**SECTION 75W MODIFICATION APPLICATION TO MP10_0230
WOOLLOOWARE BAY TOWN CENTRE**

This Section 75W Modification has been prepared to modify the Project Approval MP10_0230 for the Retail/Club Precinct at 461 Captain Cook Drive, Woollooware (Woollooware Bay Town Centre). It is submitted to the Minister for Planning and Infrastructure (or his delegate) pursuant to section 75W and Clause 12 of Schedule 6A of the *Environmental Planning and Assessment Act, 1979* (EP&A Act) by JBA on behalf of Bluestone Capital Ventures No. 1 Pty Ltd (Bluestone).

This modification application relates to minor design modifications to the approved Stage 1 Retail/Club development. Proposed amendments include minor design refinements to the retail development and amended stratum subdivision plans in response to the detailed design of the approved development.

Lengths are in metres. Reduction Ratio 1: 800

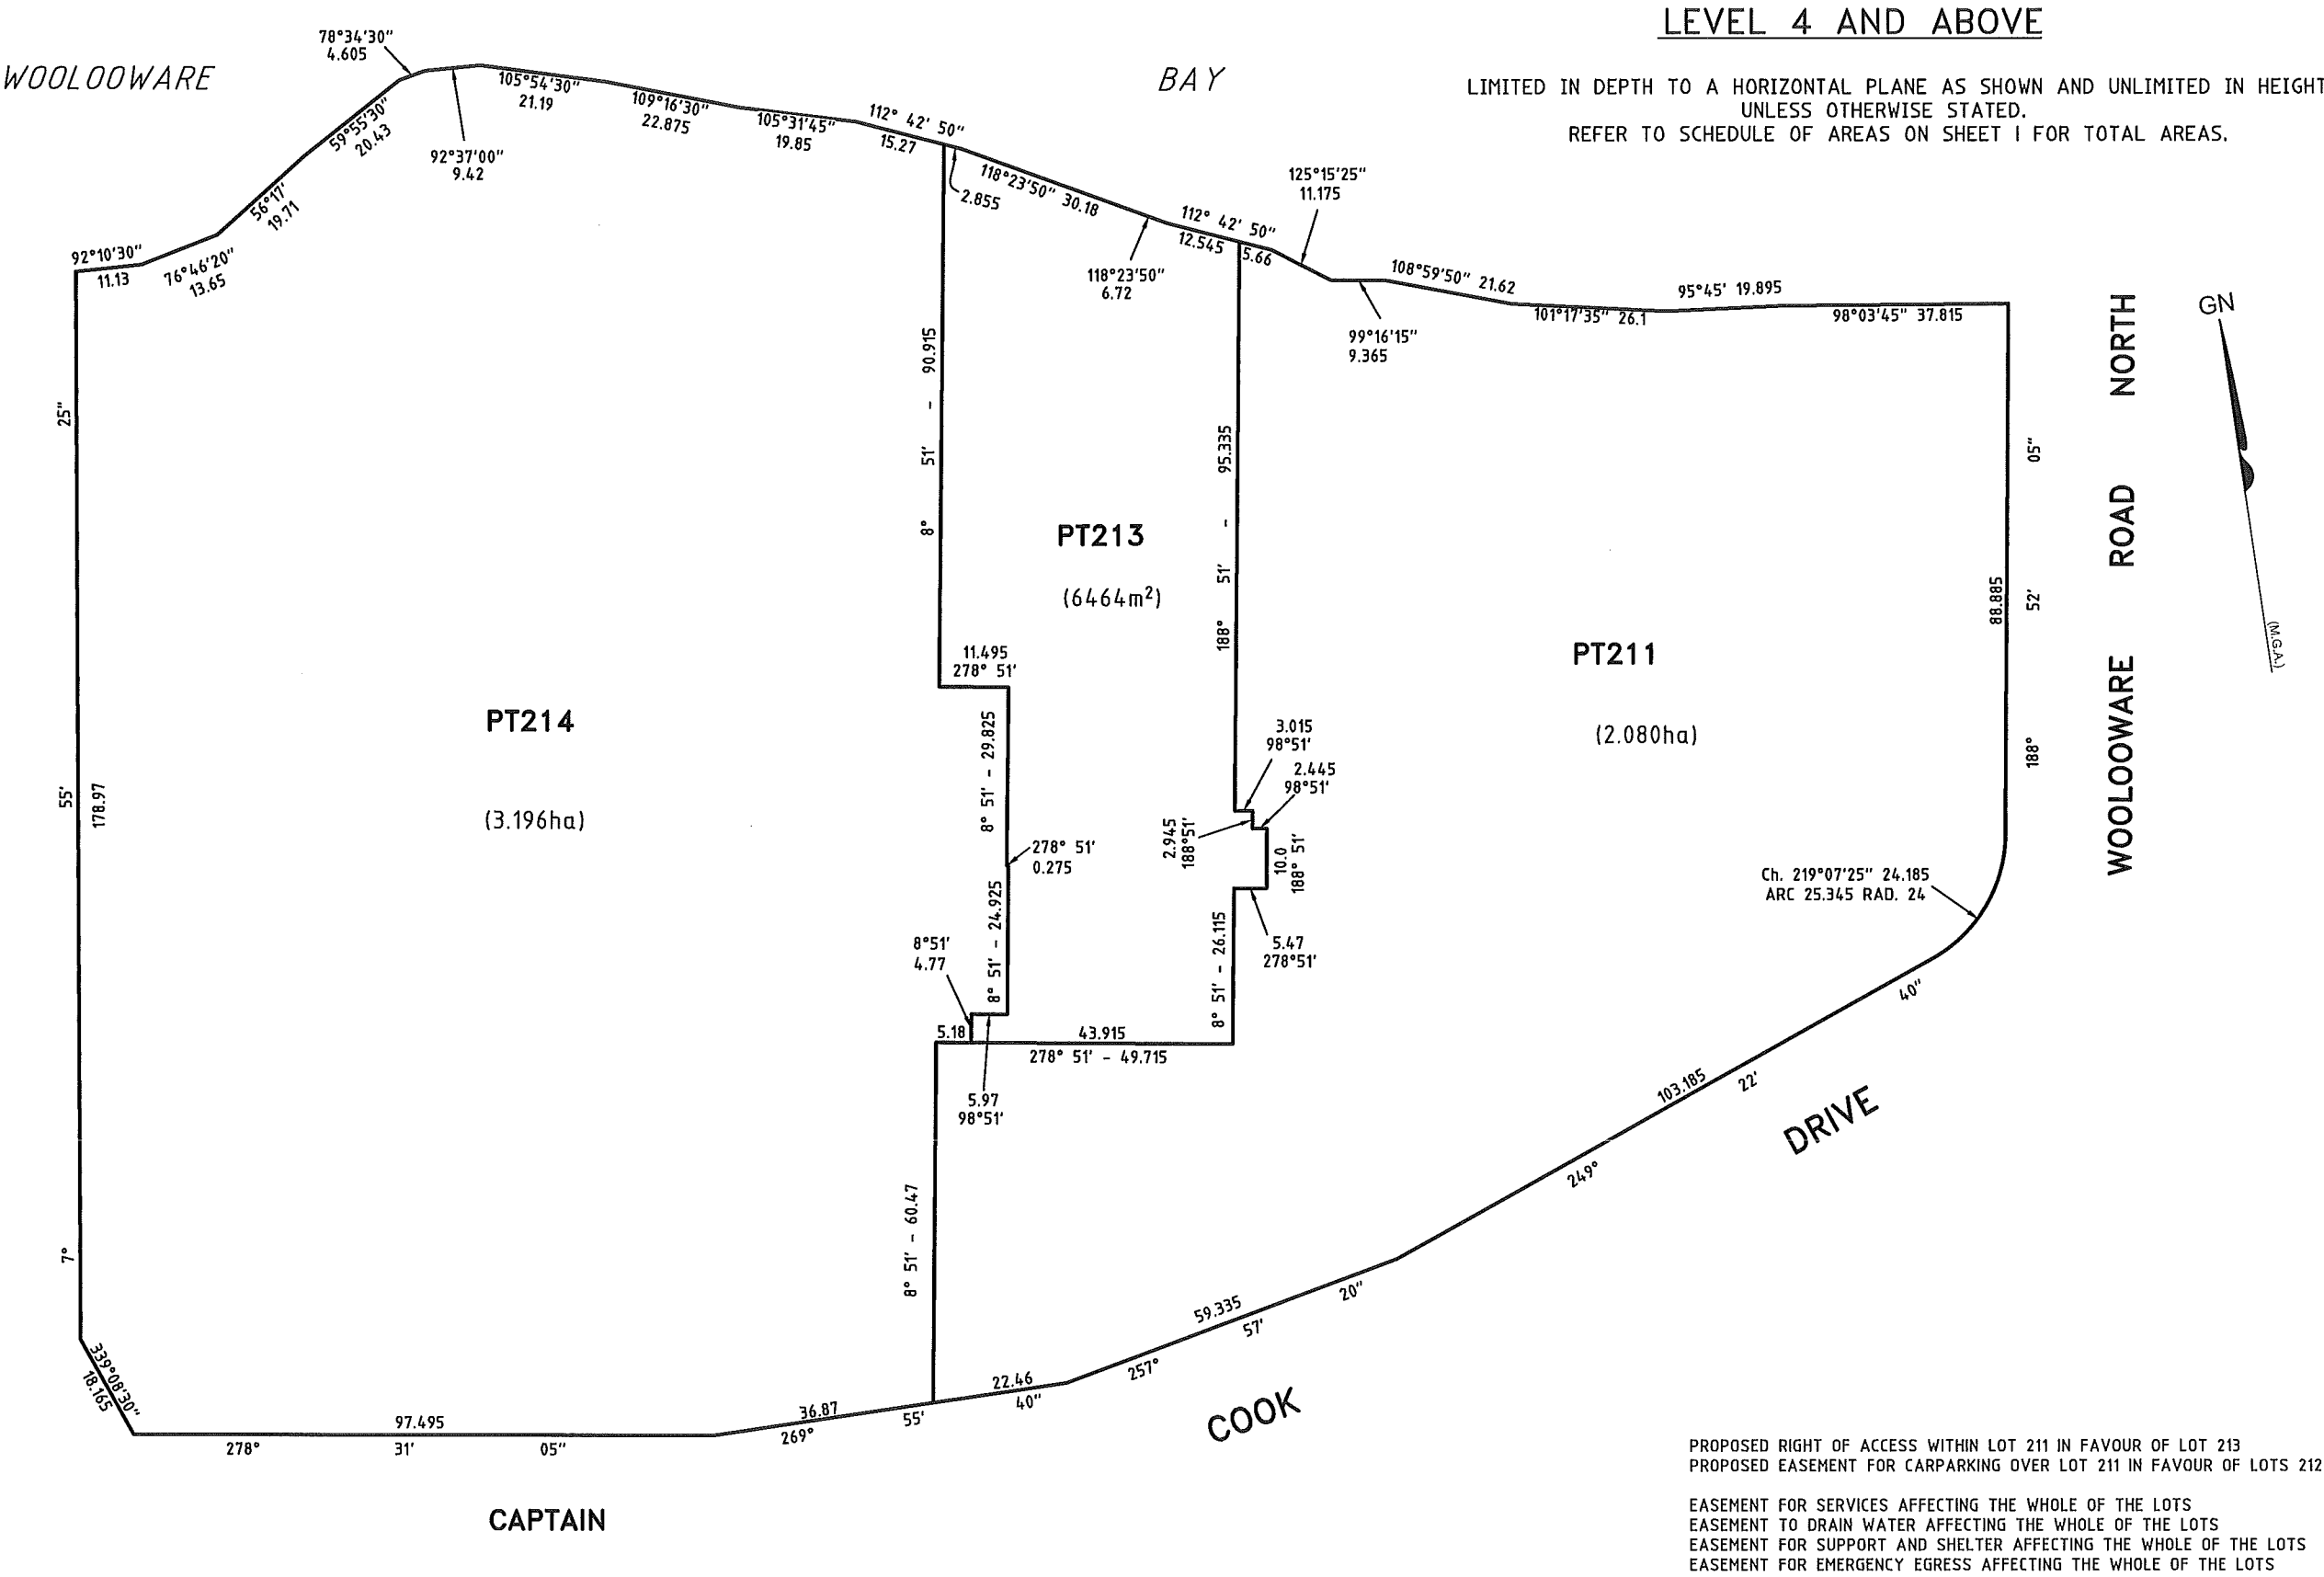
The Project Approval granted consent for the stratum subdivision of several lots in DP1180482 to facilitate the future use of the development. Due to the detailed design development of the approved scheme and the changes set out in the Amended Architectural Plans (**Attachment A**), minor boundary adjustments have occurred which has necessitated updated stratum subdivision plans. The Subdivision Plans prepared by Harrison Friedmann & Associates are provided at **Attachment B**.

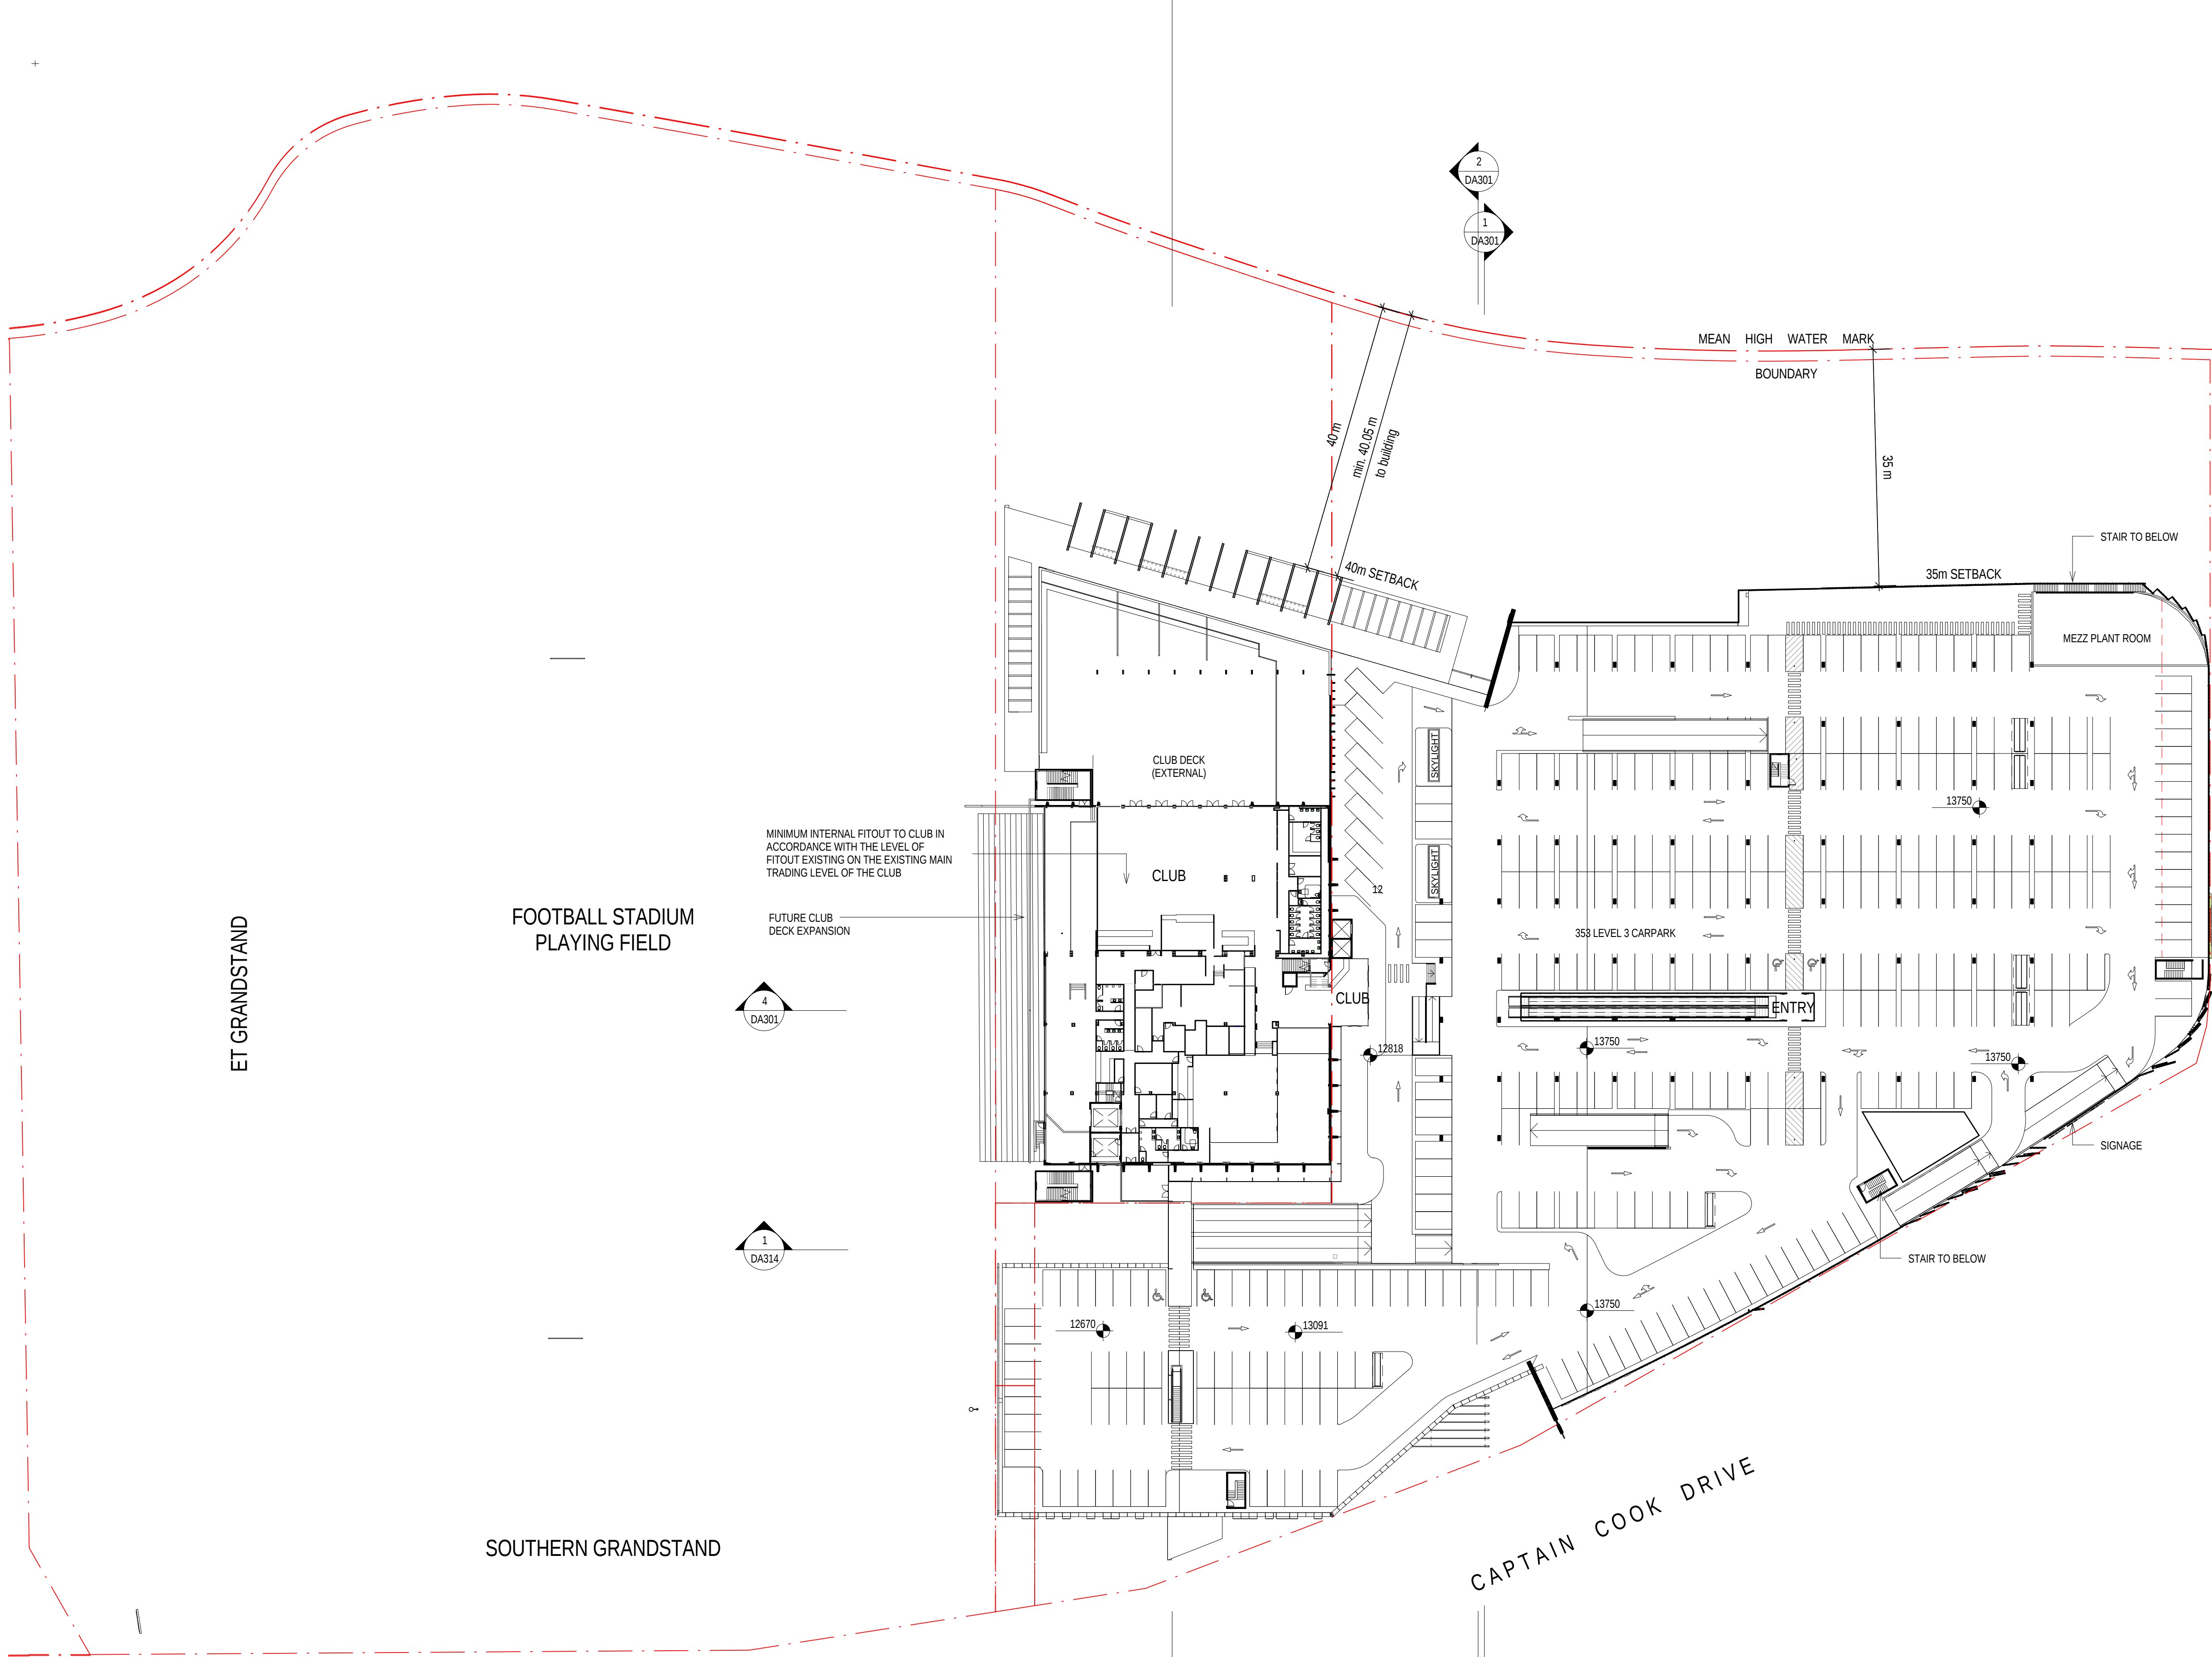
Architectural (or Design) Drawings Prepared by Scott Carver Pty Ltd			
Drawing No.	Revision	Name of Plan	Date
DA011	7	Level 1 Plan	23/05/2013
	9		17/12/2013
DA013	7	Level 3 Plan	23/05/2013
	8		17/12/2013
DA014	4	Level 4 Plan	07/06/2013
	6		17/12/2013

Minor design refinements have been made to the internal layout of the approved retail and club development. Amended Architectural Plans prepared by Scott Carver are provided at **Attachment A**. These changes generally comprise an amended Cronulla Sutherland Leagues Club layout better suited to the needs of the Club. Reconfigurations are proposed to components of the approved club fitout on levels 1, 3 and 4. These include an amended game day bar area on level 1 and the reconfiguration of room layouts on level 3 and 4, including the club restaurant.
